## **Pear tree Hill Solar Farm**

# **Response to Report on the Implications for European Site**

Application Document Ref: EN010157/APP/8.24  
November 2025

Figure 3 Target species observations

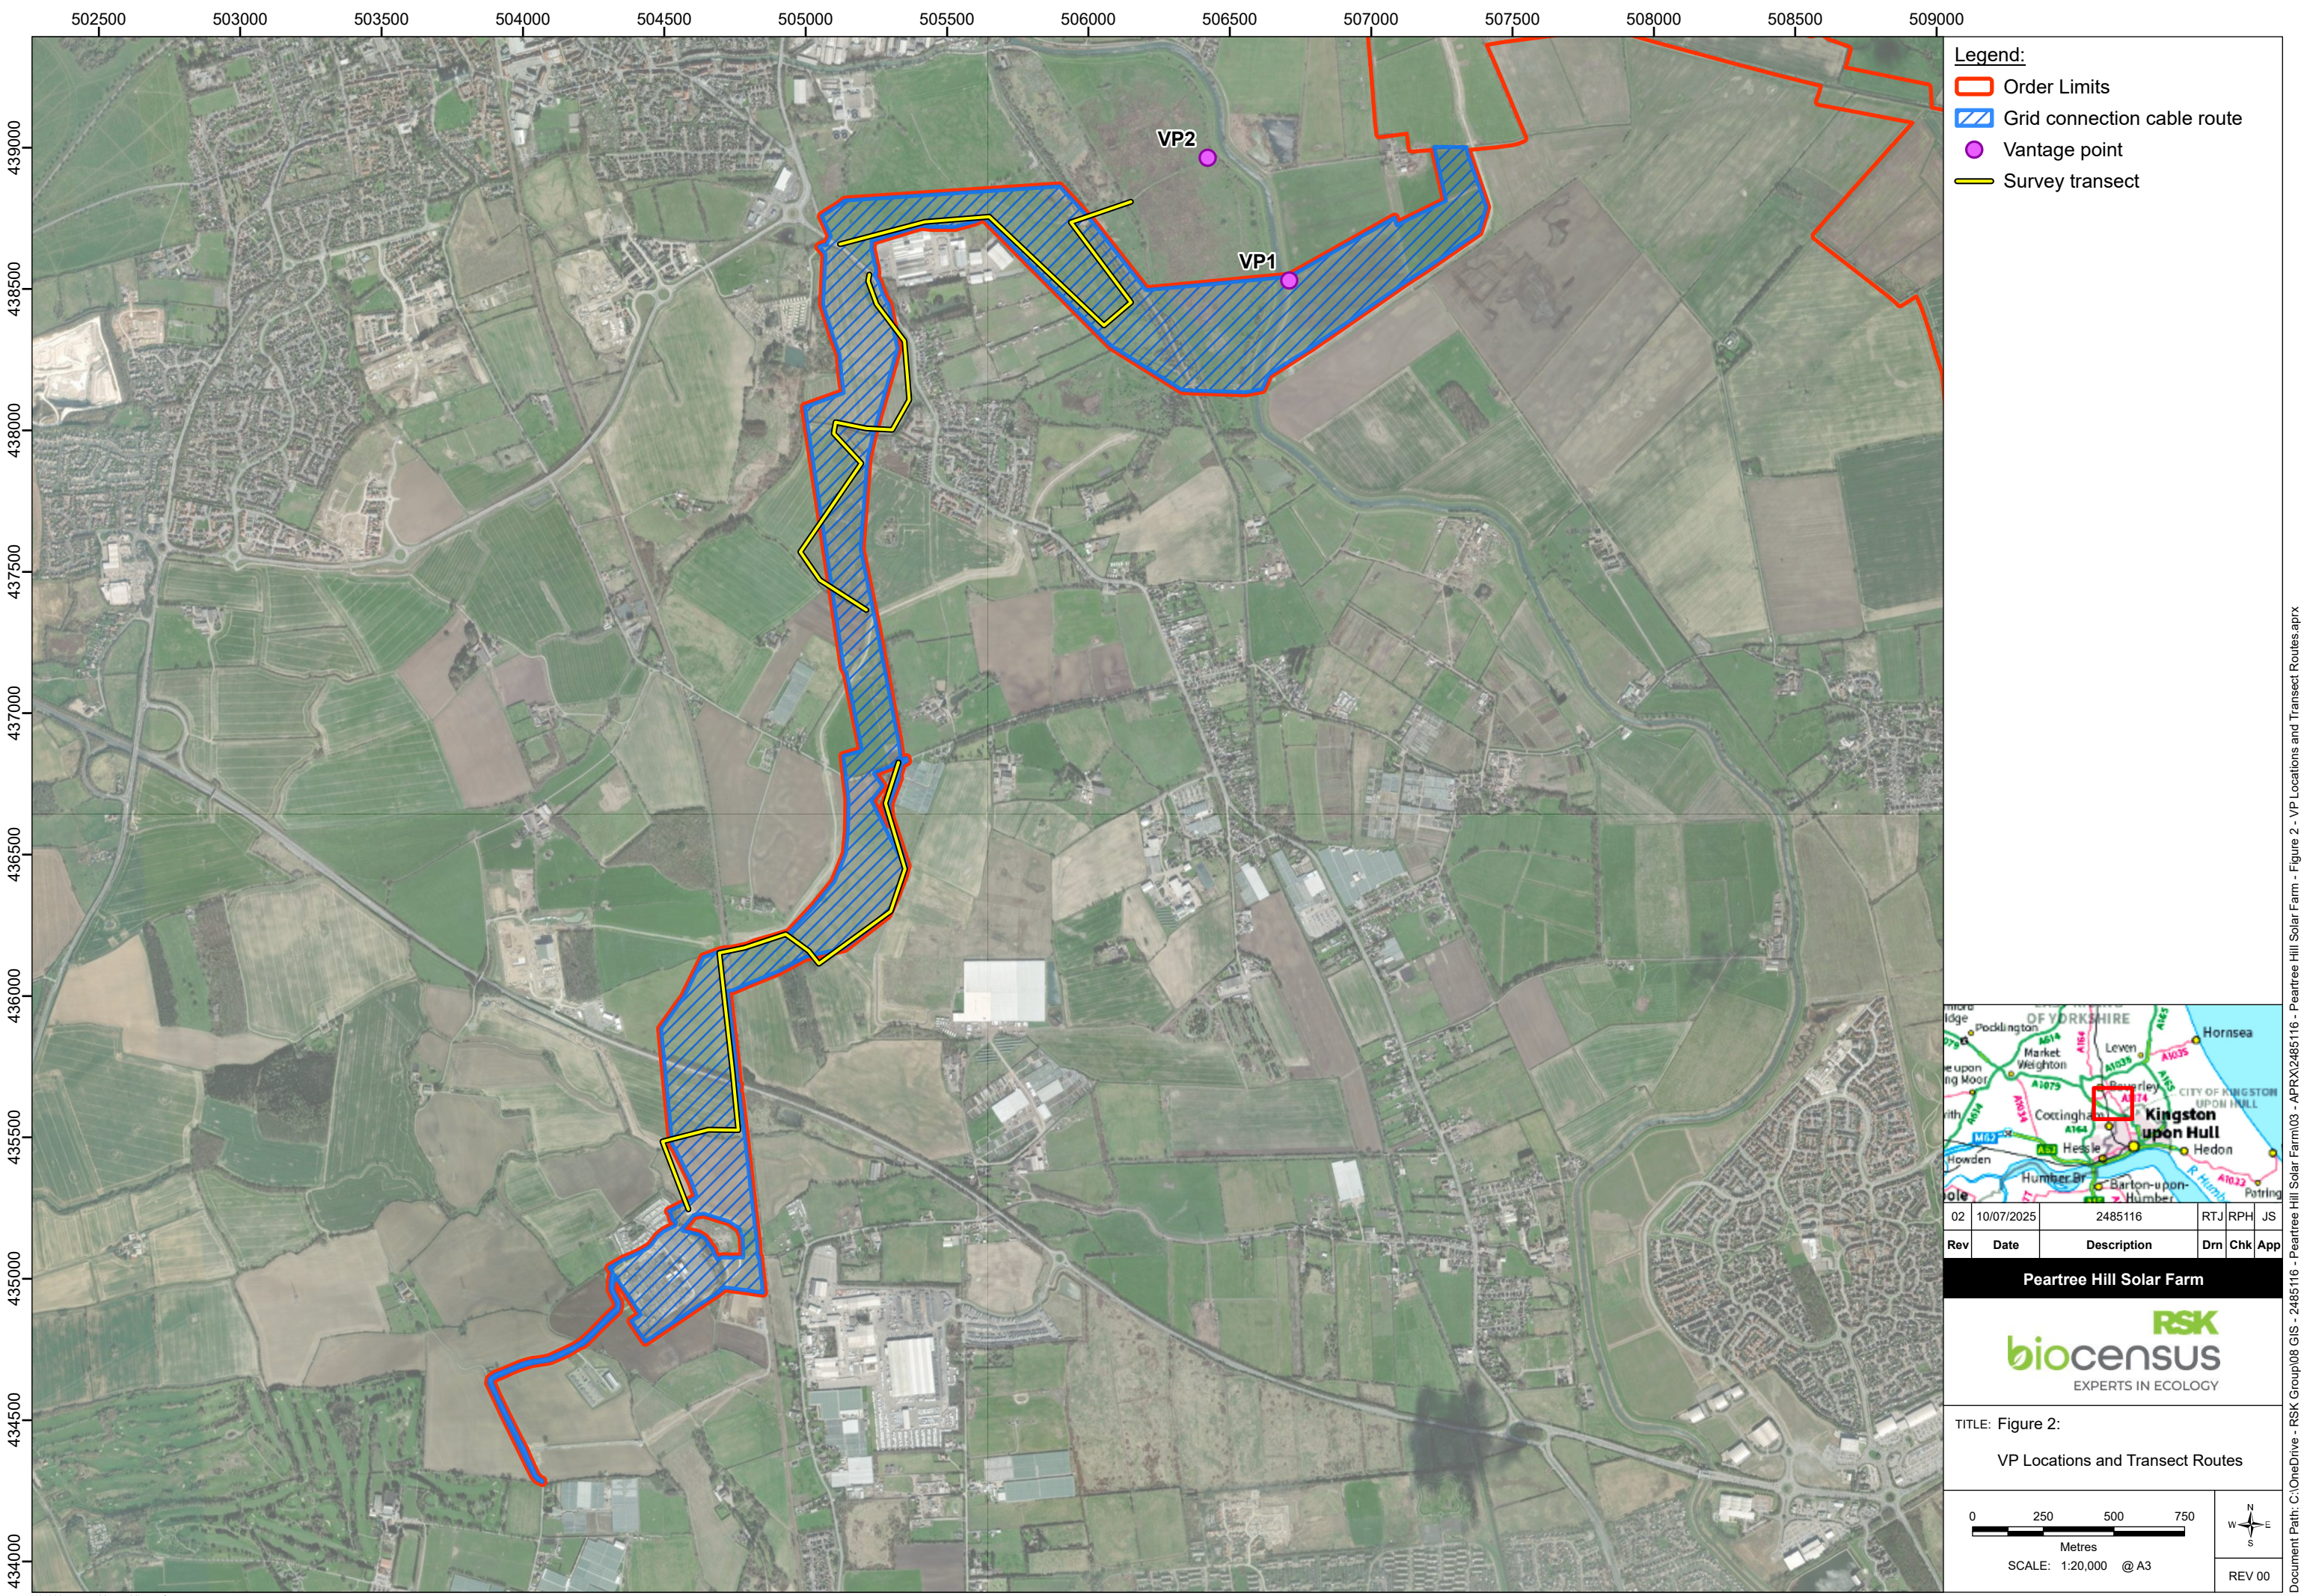
3.1.5	<p>Potential loss of FLL.</p> <p>Passage/ wintering bird surveys of the grid connection cable route – construction and operation.</p>	<p>NE [REP2-154] on review of the Grid Connection Bird Survey Report [REP1-072] and the inclusion of the new data in the HRA Report [REP1-015] advised that further assessment should be provided to determine whether the proposed measures are sufficient in the context of the updated bird survey results, particularly regarding potential impacts to pink-footed geese. NE noted that noise and visual disturbance impacts resulting</p>	n/a – matter resolved	The Applicant notes this comment.

ID	Potential impact pathway	Details of Issue	ExA observation / questions	Applicant's response
		<p>from temporary loss of and disturbance to FLL will need to be considered.</p> <p>The applicant updated the HRA Report [REP3-014] to provide further consideration in relation to pink-footed geese recorded within the grid connection cable route. The applicant stated in its draft SoCG with NE [REP3-047] that during the 2024/25 bird surveys, pink-footed geese were seen flying over on four occasions and were only recorded twice within the order limits. The applicant further stated that although the numbers recorded within the order limits were more than 1% of the SPA population, the grid connection cable route is not considered to constitute FLL for pink-footed geese.</p> <p>NE's D4 submission [REP4-084] agreed that pink-footed geese would not be significantly affected by disturbance/displacement from FLL within the grid connection corridor during construction due to shortterm nature of construction works and the mobile nature of pink-footed geese and noted that the agreed</p>

ID	Potential impact pathway	Details of Issue	ExA observation / questions	Applicant's response
		<p>non-breeding bird mitigation areas would also provide additional feeding areas for this species during this period.</p> <p>NE stated that it did not agree with the applicant's conclusion of the grid connection cable route not being considered to constitute FLL for pink-footed geese but advised that significant effects on this species can be ruled out based on the factors outlined above.</p>
